An
Bord
Pleanála

Inspector's Report ABP-309119-21

Development	110kV "loop in-loop" out substation with underground transmission cables & associated works.
Location	Drumanan and Cornawall, Newbliss, Co. Monaghan
Planning Authority	Monaghan County Council
Applicant(s)	Drumlins Park Ltd.
Type of Application	Permission
Type of Case	SID
Observer(s)	Monaghan County Council Dept. TCAGS&M (DAU) Transport Infrastructure Ireland Geological Survey Ireland Environmental Health Service
Date of Site Inspection	23 rd April 2021
Inspector:	Karla Mc Bride

Drawing file: 11. Planning Drawings / Figure 20 - Typical Cable Trench Section Specification.pdf

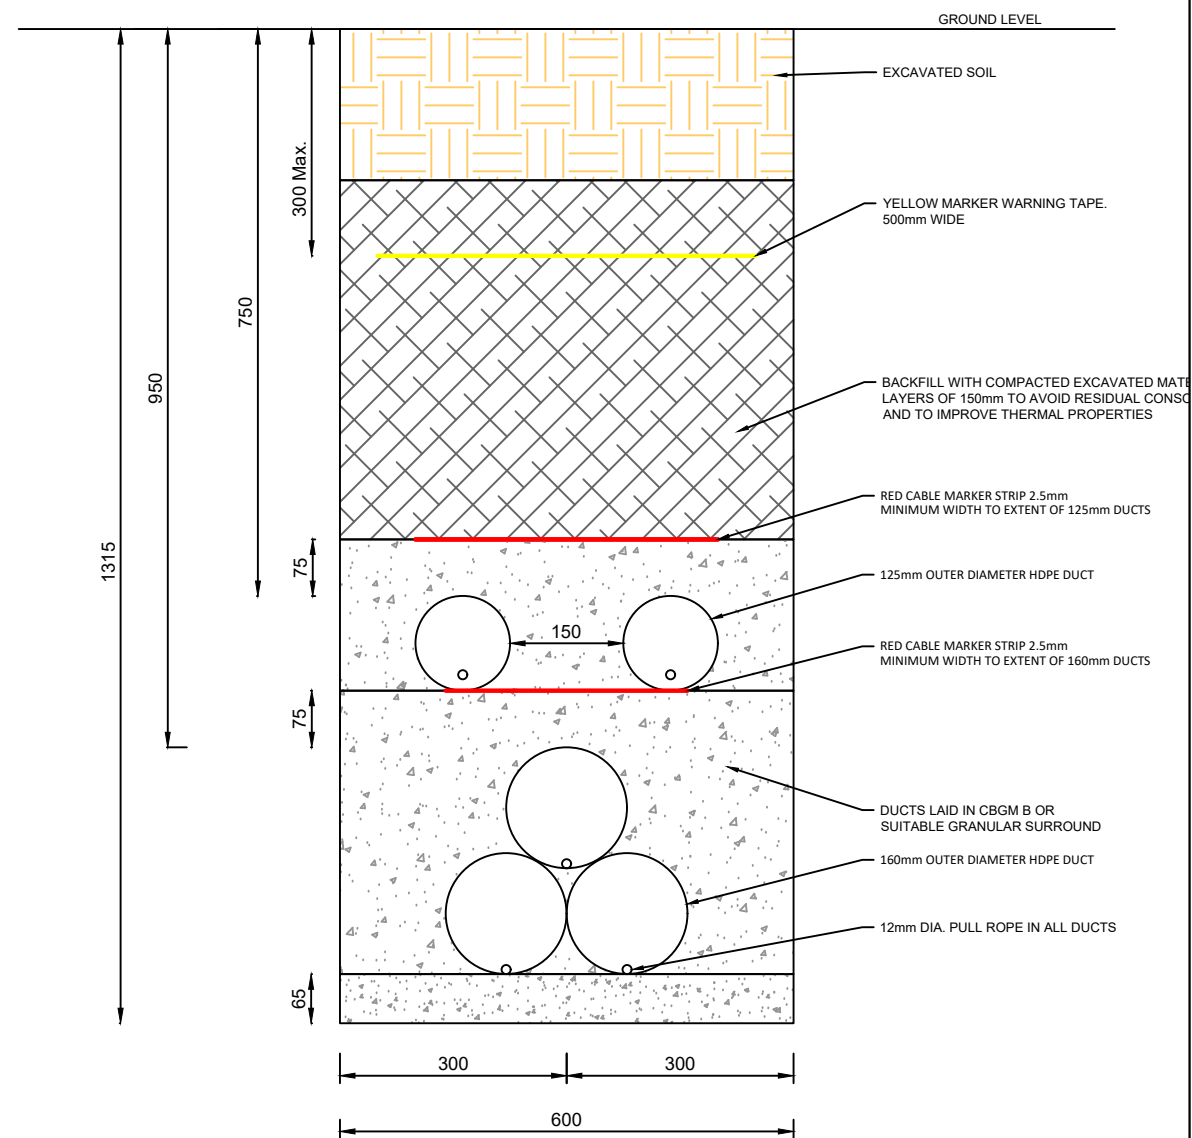
- Consider the construction of single entrance instead of two.
- Electricity line ducting arrangements have not been provided where ducting intersects with existing culverts/drainage pipes along LT62013.
- Additional details of the surface water drainage system required: -
 - The QBar calculation for the site;
 - The location of the surface water restriction device or throttle;
 - The permitted rate that surface water generated from the construction of impermeable surfaces within the site will be allowed to discharge to the nearest watercourse;
 - Inclusion of a petrol interceptor;
 - Calculations to substantiate the attenuation storage volume required for a 1/100-year storm event

- The underground line between the substation and end masts will be mainly located within private fields and most ducting works will not interact with existing culverts traversing the LT62013. However, a short section of underground line (c.15m) will adjoin this road as it traverses a private laneway. Drawings contained in Annex 1 of this submission describe typical ducting arrangements which will ensure no adverse effect on the existing drainage regime:

- should the proposed underground line interact (crossing under or over) with existing culverts or drainage pipes; and
 - where the proposed underground line will interact with existing open drainage ditches within private lands.
